Please ask for: Mrs D Johnson
Email: daun.johnson@arun.gov.uk
Telephone: 01903 737762
Our Ref: AL/97/21/CLP
Your Ref:
Date: 26th July 2021

Lawful Development Certificate for a Proposed Use or Development

Development: Lawful development certificate for the proposed refurbishment of existing Orangery, and refurbishment of loft and to use velux windows for additional light in loft.
Location: Lidsey Lodge Cottage Sack Lane Lidsey PO22 9PE

EXISTING LOCATION PLAN
Lidsey Lodge

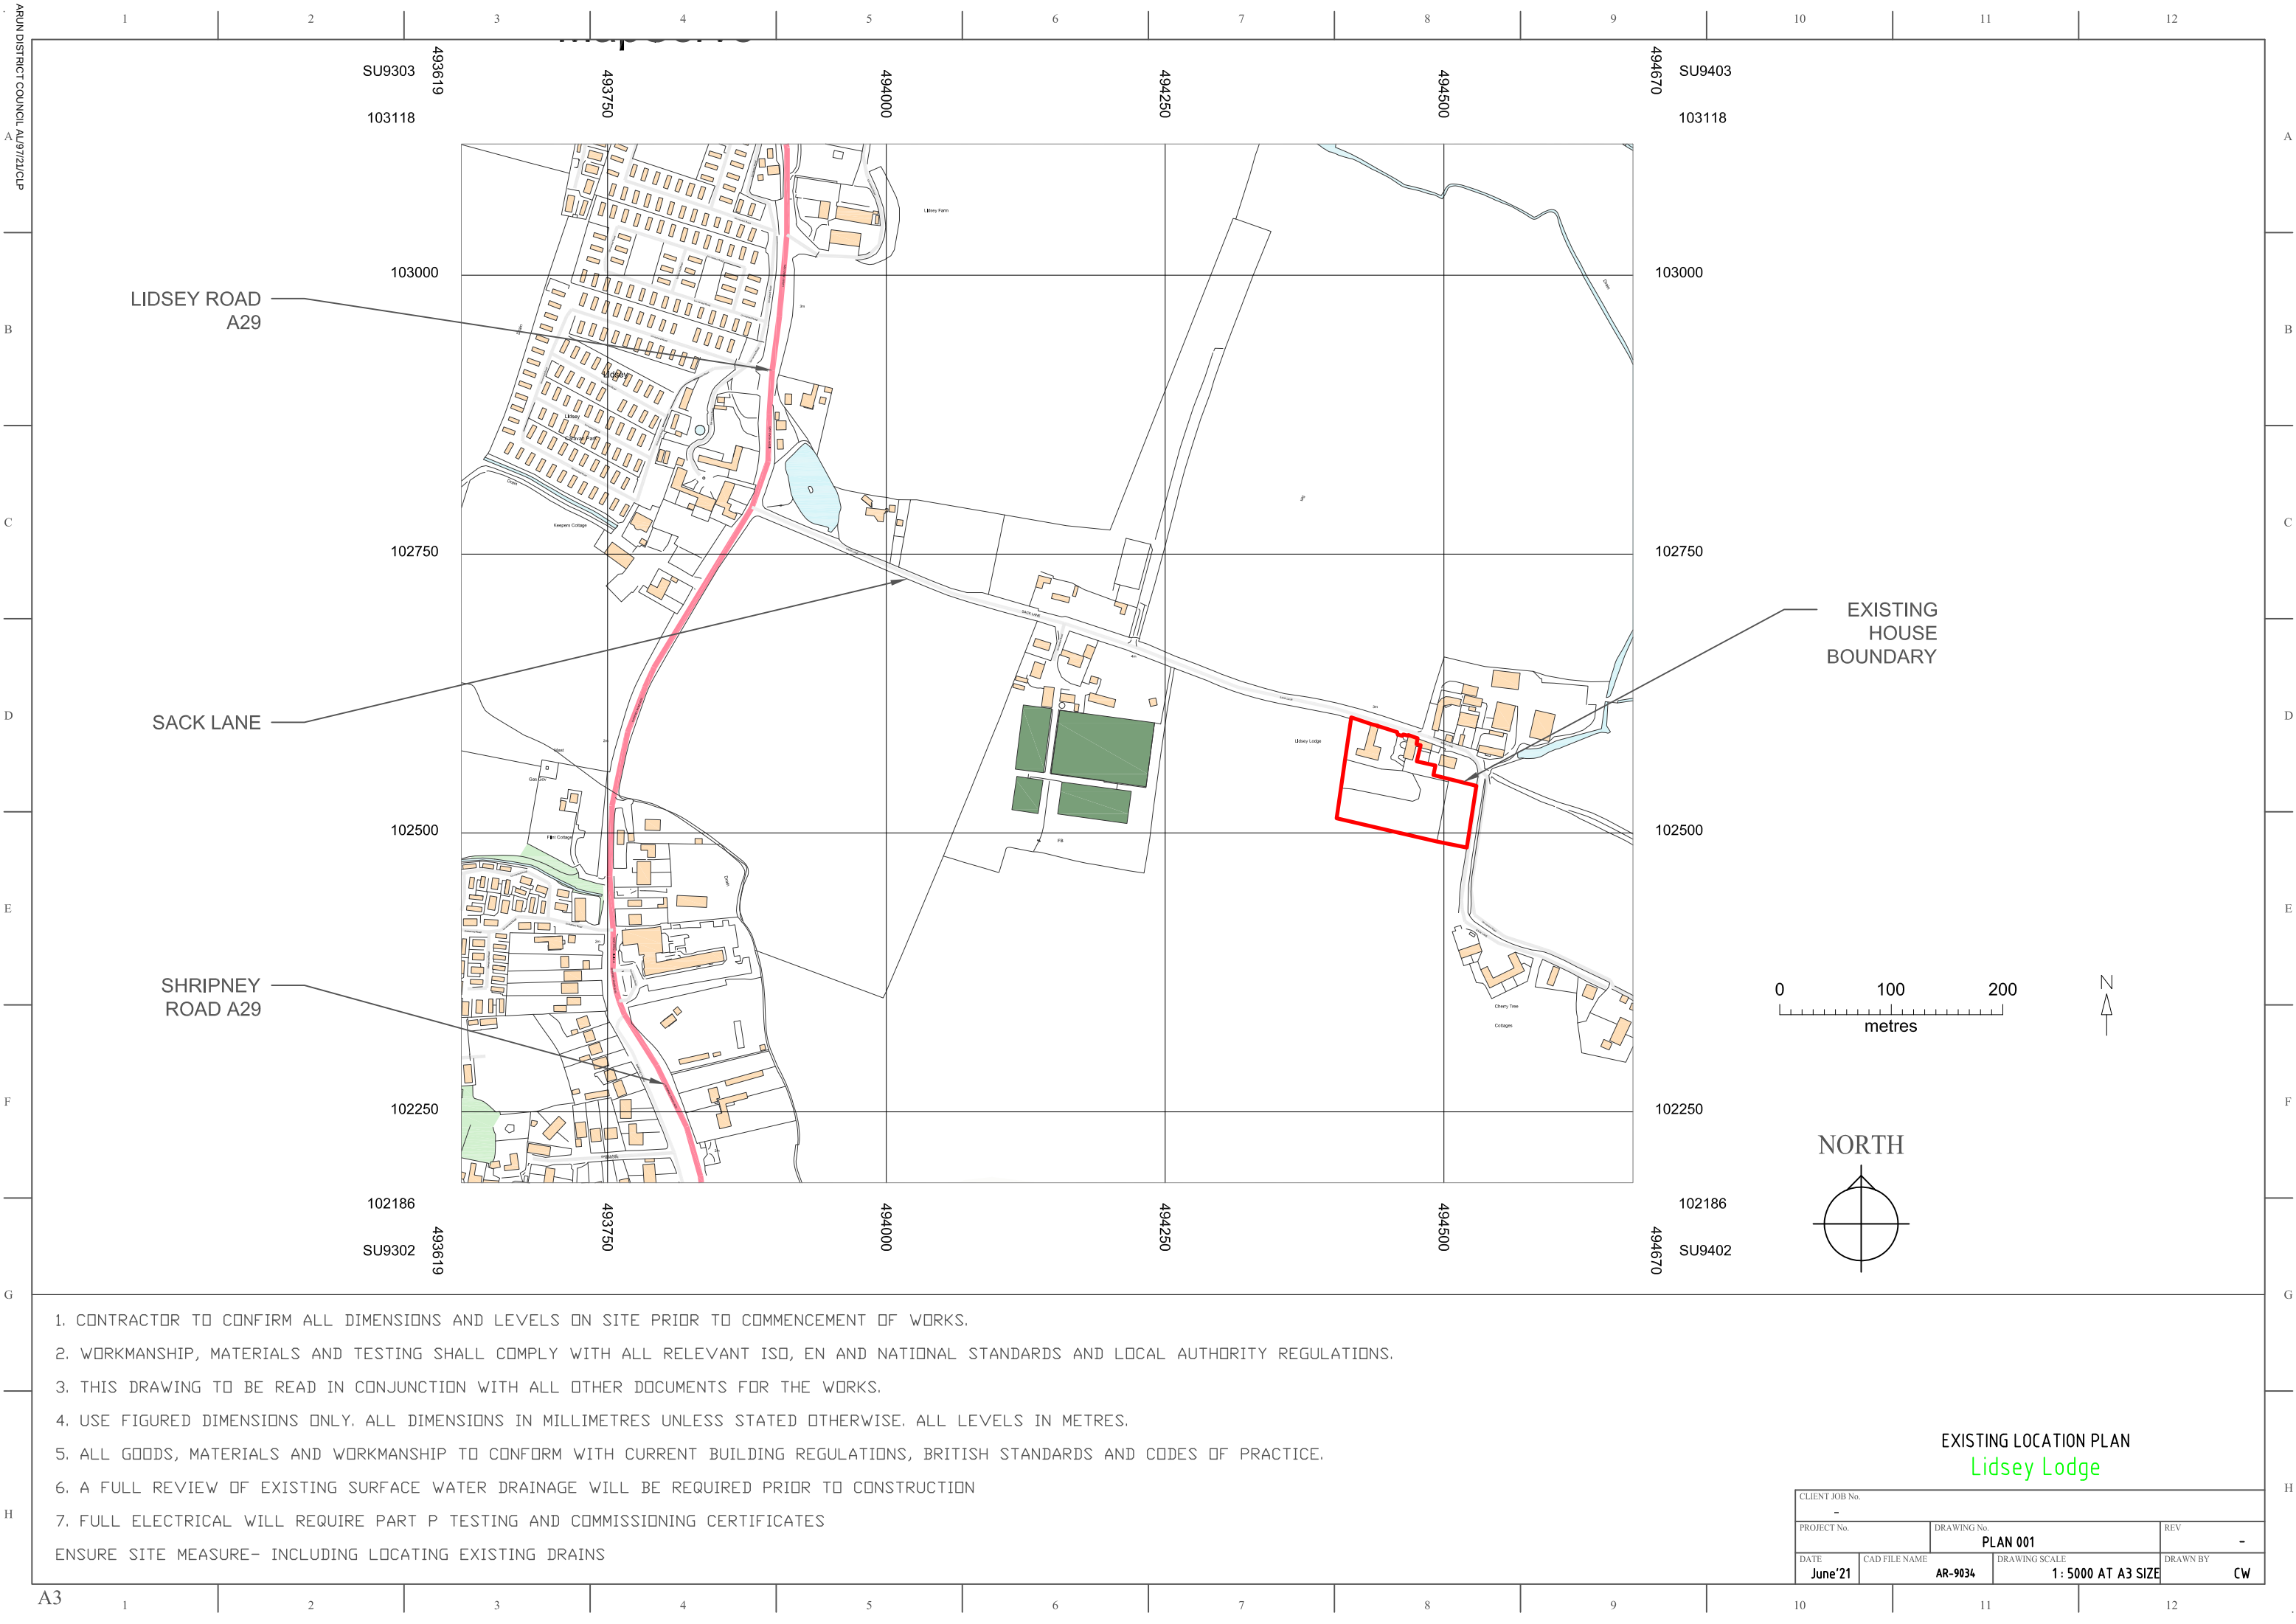
On the location plan (Plan 002) please indicate which dwelling is having the proposed refurbishment.
